A46 Newark Bypass

Scheme Number: TR010065

7.58 The Applicants Responses to Comments Received at Previous Deadlines

December 2024

**Figure 3-2 Interface with Cree's Lane embankment**

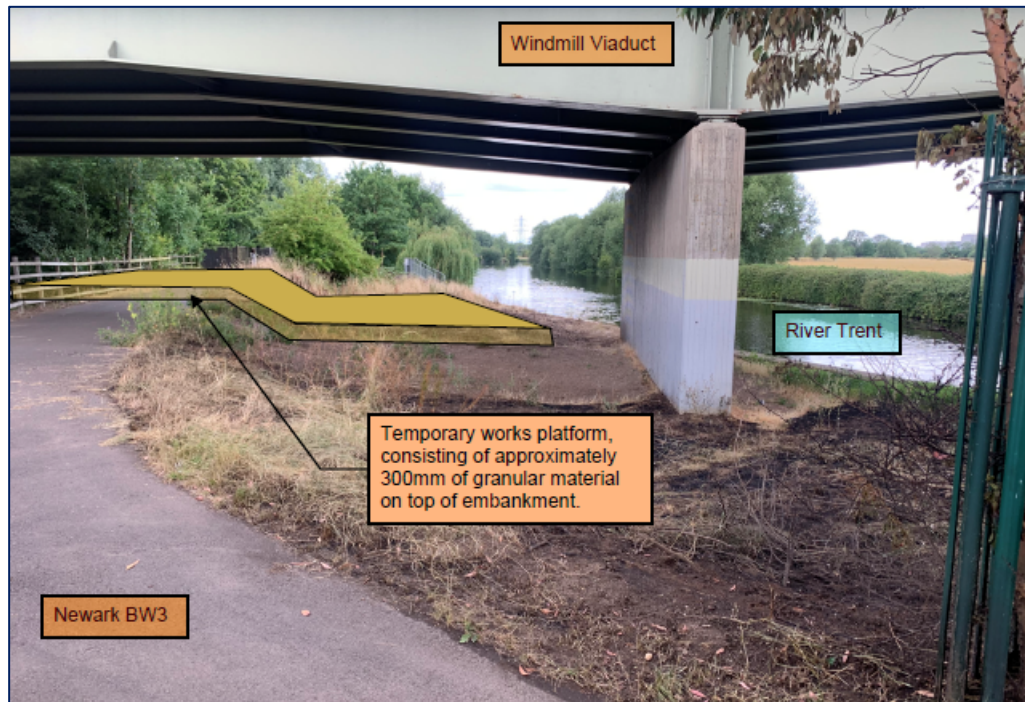
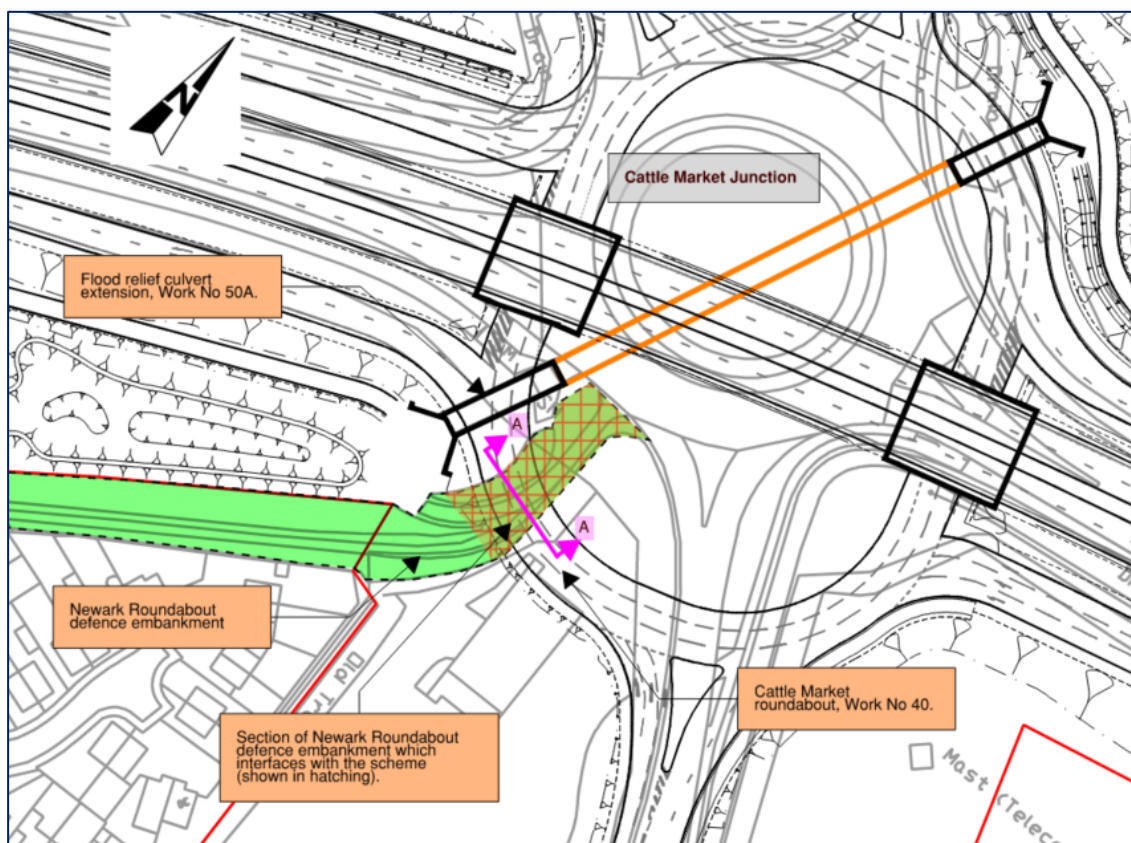
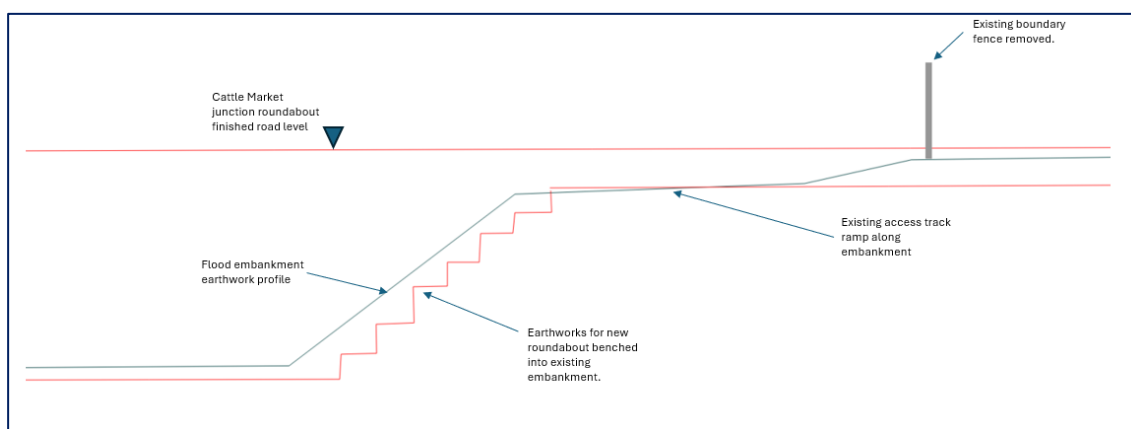
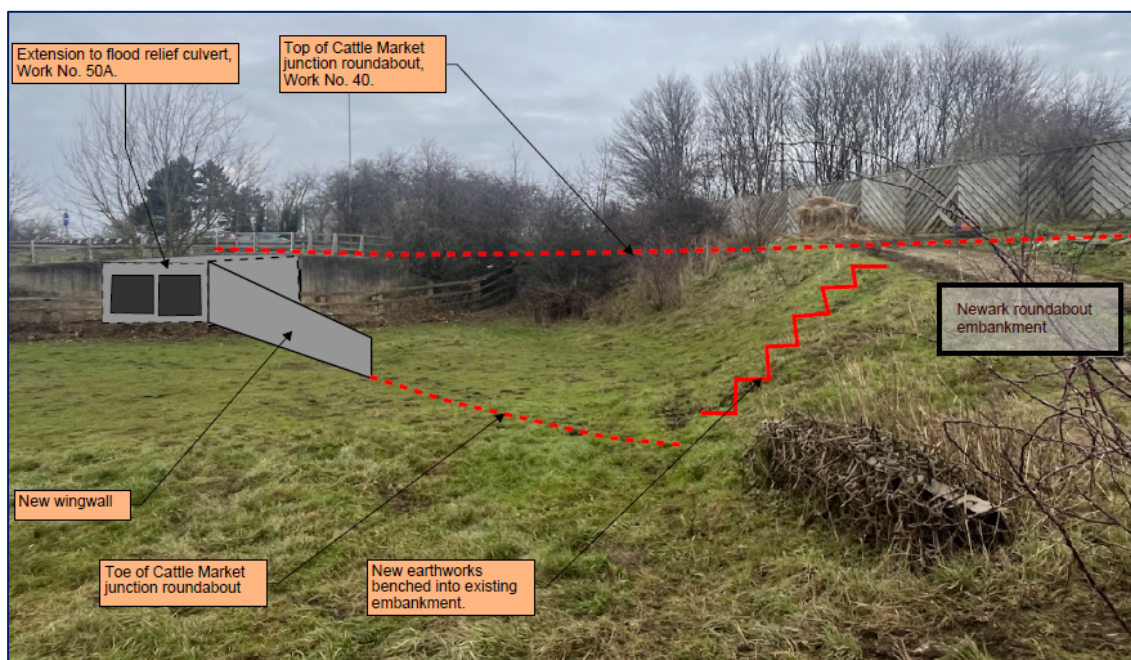
Environment Agency - Comments at Deadline 3 – 26 November		The Applicant's Response
	in ExQ1 [REP2-042] and in our WR [REP2-043] on issue ref. EAFR-008 remain applicable. The Applicant's response to this question is also included in their response to our RR [REP1-010]. The drawing that is referenced does not show any cross-sections and there is no evidence to demonstrate that any of our defences will not be compromised.

<p>3.11 Q15.1.4 Interaction with Existing Flood Defences We note the Applicant's response to this question and our comments provided in our response to this question</p>	<p>The Applicant will provide cross sections of the interface between the existing flood defence embankments and the proposed scheme design prior to Deadline 5.</p>
